Application No: R/116/21/HH
Site Address: 17 Mill Close Rustington BN16 3HR
Description of works: Erection of single storey rear extension

Thank you for your internet representation made on 12th June 2021 which has been recorded as an objection with the comments as follows:

Planning application ref no: R/116/21/HH - Planning Application for erection of single storey rear extension at 17 Mill Close.

Plans & Elevations As Proposed

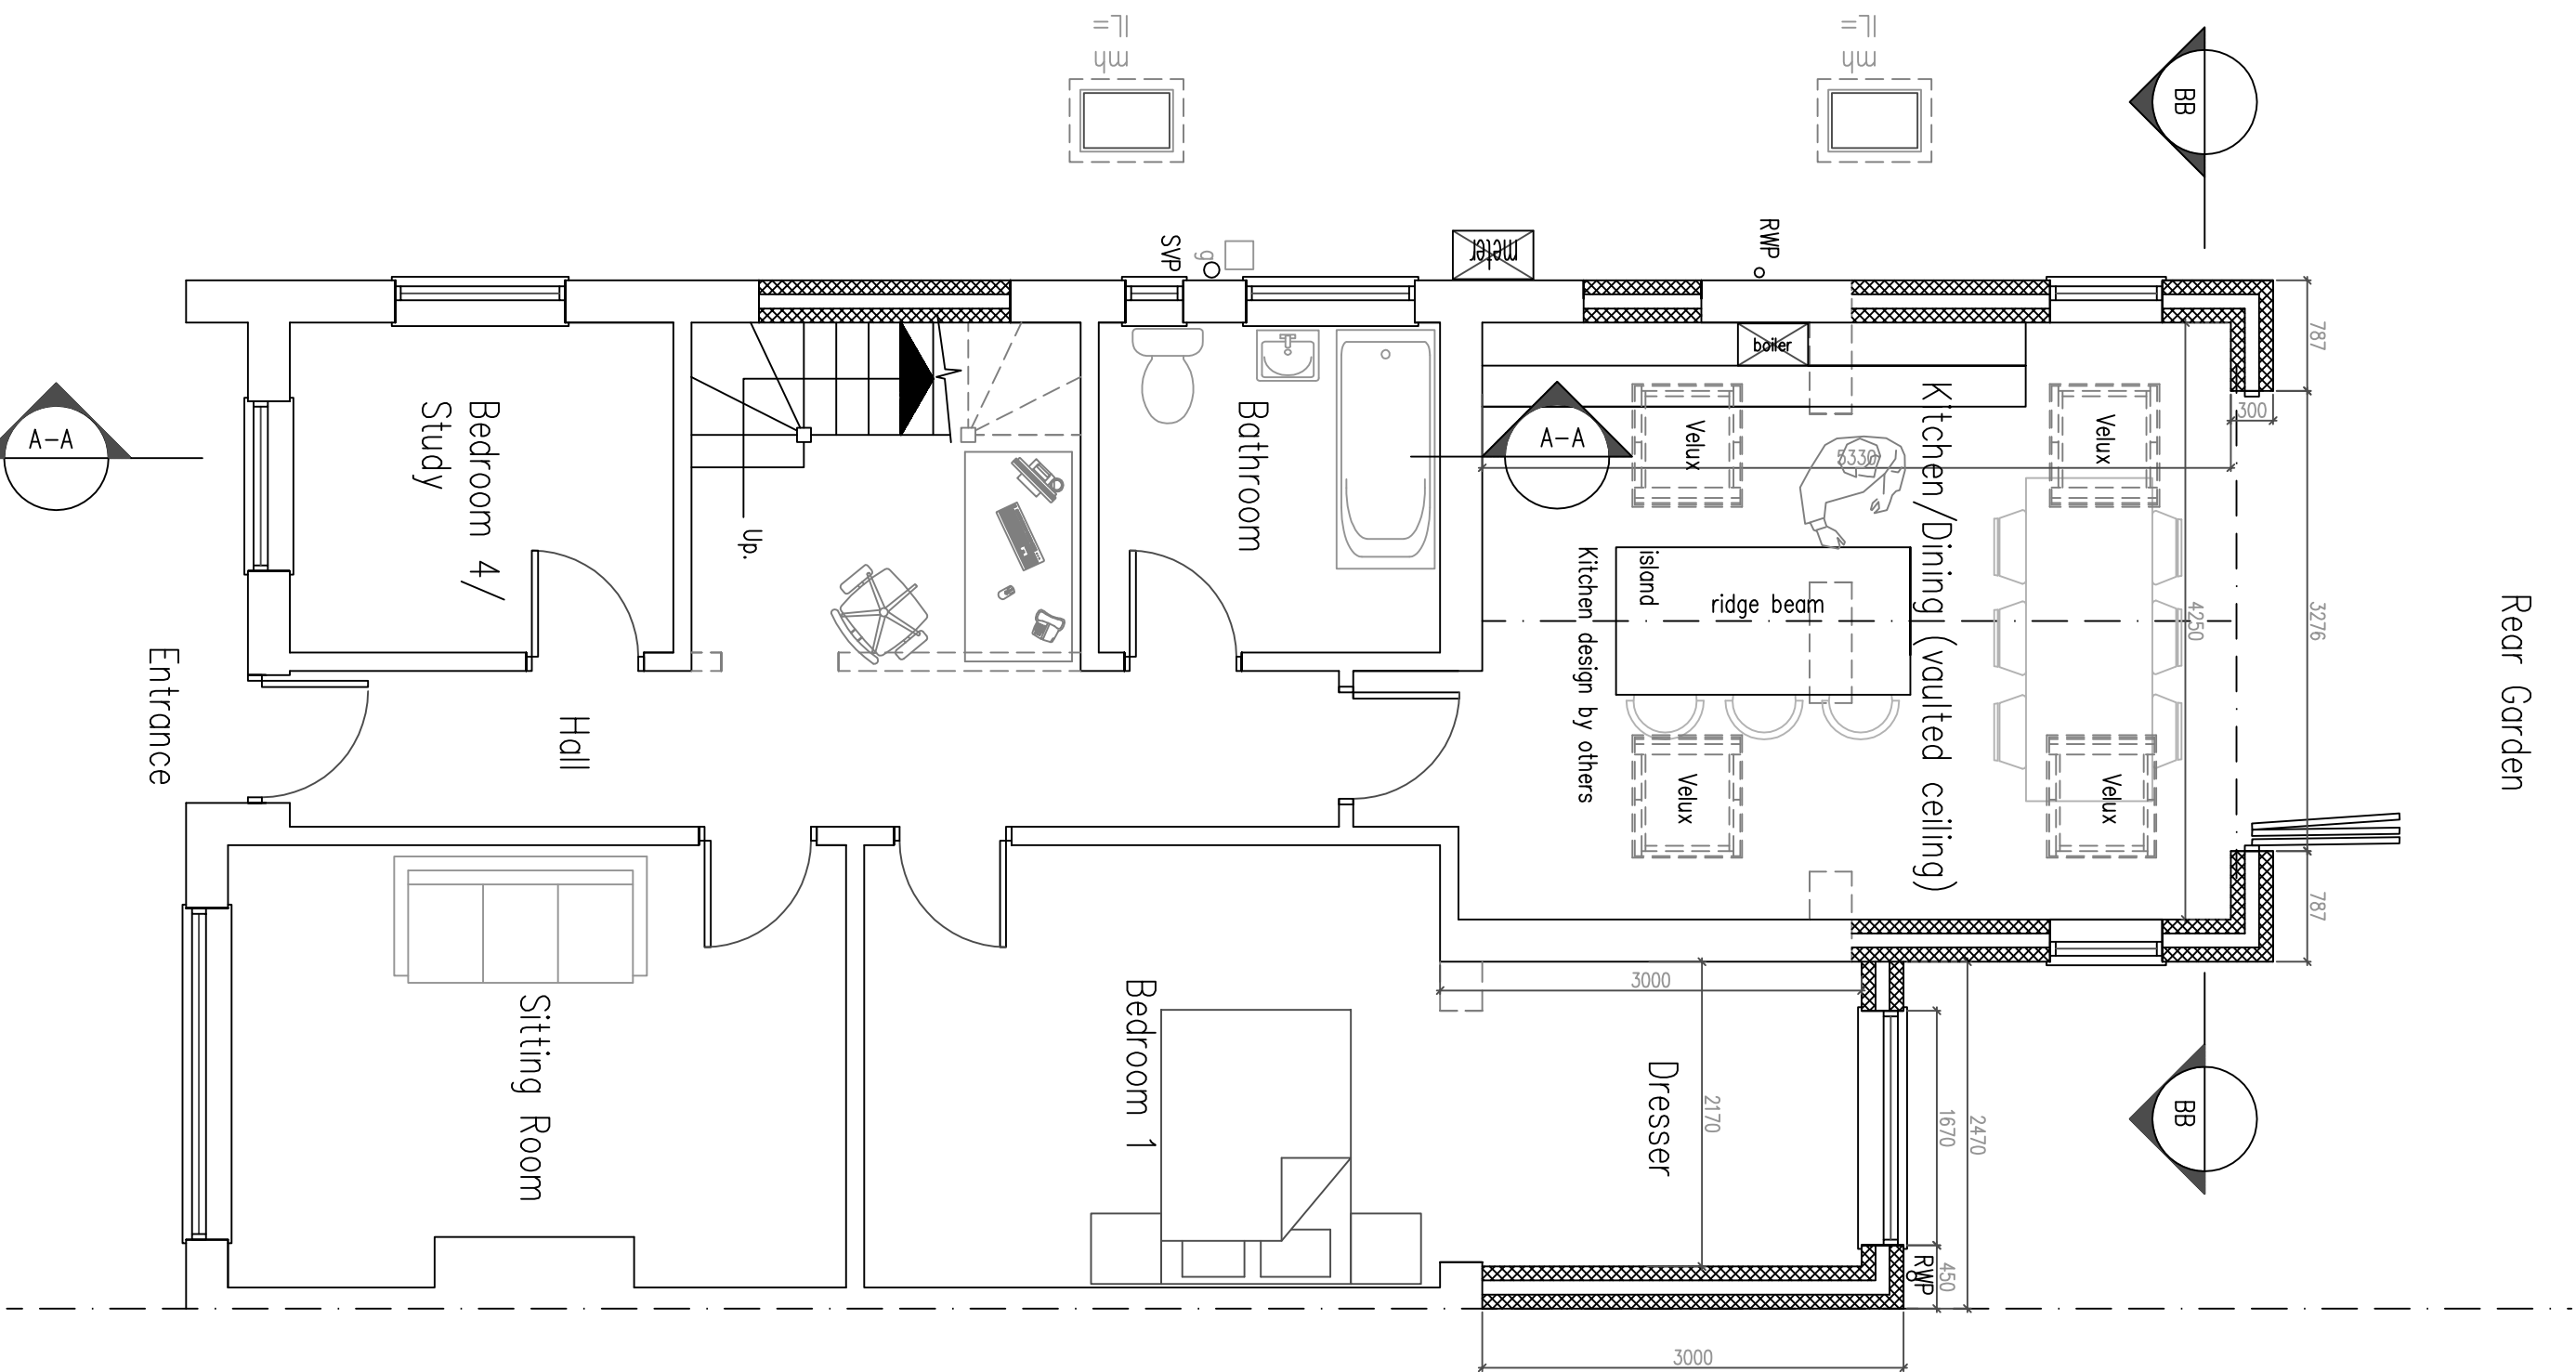
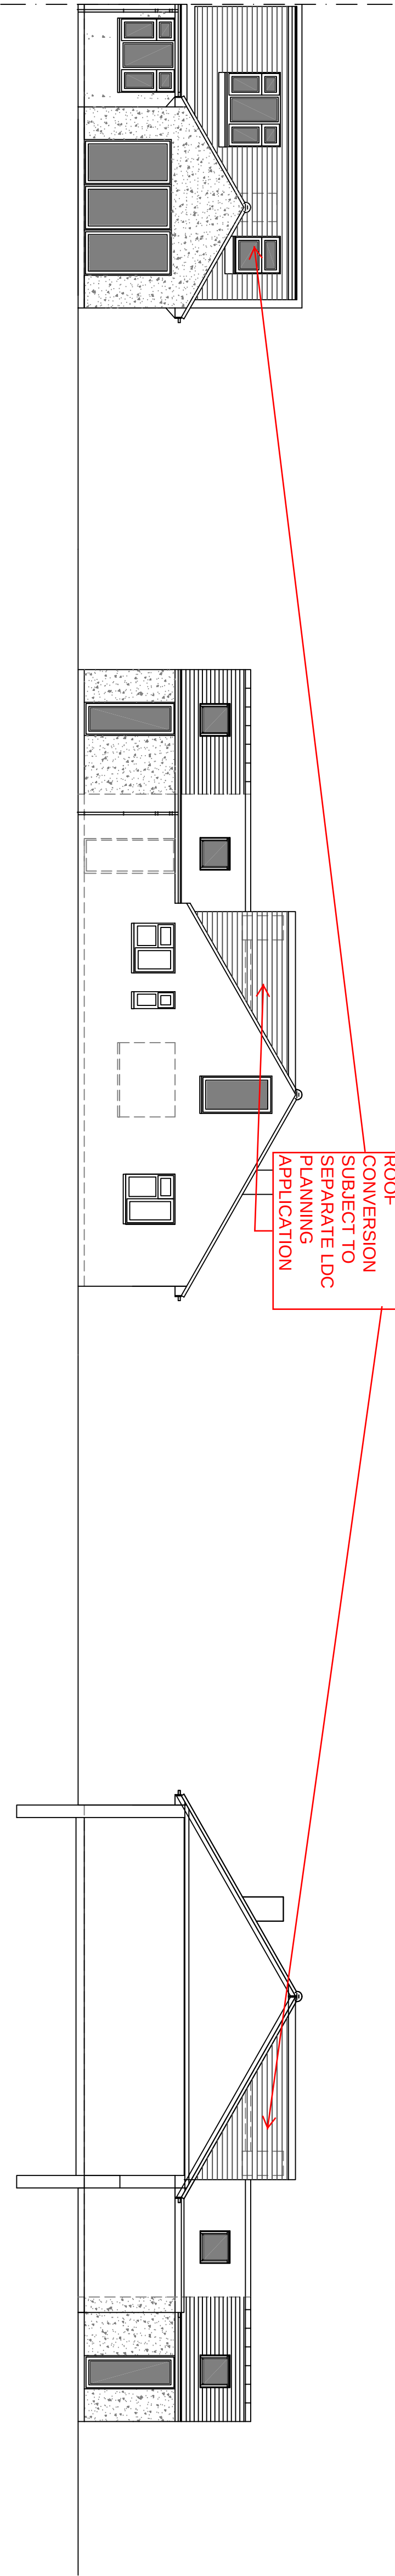
I am concerned that this planning application is very confusing. The proposals are covered by two applications. The planning application is only in relation to the single storey extension. The roof extension and alterations are the subject of an application for a Lawful Development Certificate (LDC). The plans submitted with the planning application show the proposed roof alterations which do not form part of that application. This is not only confusing but, even though there is a note referring to the LDC, if the Council gave approval for the extension it might imply that they were also granting permission for the roof works. The plans should be changed to remove anything that does not relate explicitly to the planning application.

However, insofar as the alterations and extension to the roof are concerned I do object. The large rear facing dormer window will be un-neighbourly. It will result in a loss of privacy to the residents at the rear by way of overlooking. As such there will be a harmful Impact on residential amenities of neighbouring residents.

Although the layout of the roof alterations and extension are not included, it is clear that the amount of additional roof space created is considerable when related to the existing, modest amount of usable roof

space of the bungalow. If additional roof space is required then it would be far better to have the dormer window at the front which would remove any overlooking and be in keeping with the dormer already existing on the other half of the semi detached. Any windows on the north east side of the bungalow as extended at roof level should have opaque glass to ameliorate some overlooking.
